Re: Status of Improvement Permit Application HTE # 08-5-21025 R

Bryan McSwain, R.E.H.S.
Environmental Health OSWW Program Specialist
Harnett County Department of Public Health
Environmental Health

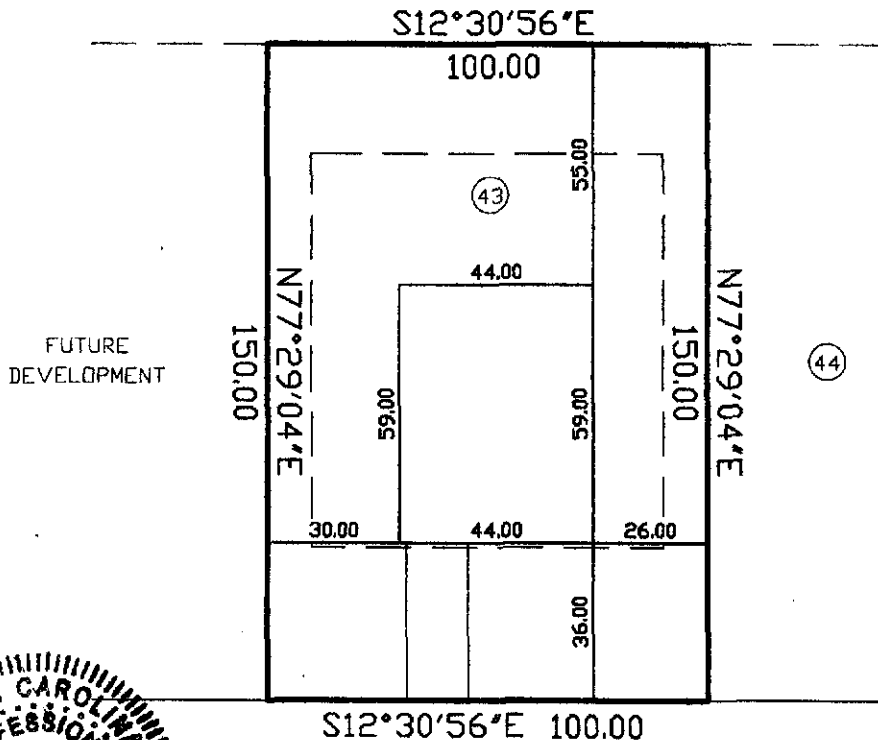
1. Use pink flags to mark property lines and irons that are set by surveyor need to be visible. (*\$25.00 fee incurred*)
2. Use orange flags to mark house corners
3. Directions not clear to property (*\$25.00 fee incurred*)
4. Property needs only brush or vegetation removed
5. Backhoe pits required
6. **Other- Site plan must be revised to show house site 75ft. from back property line.**
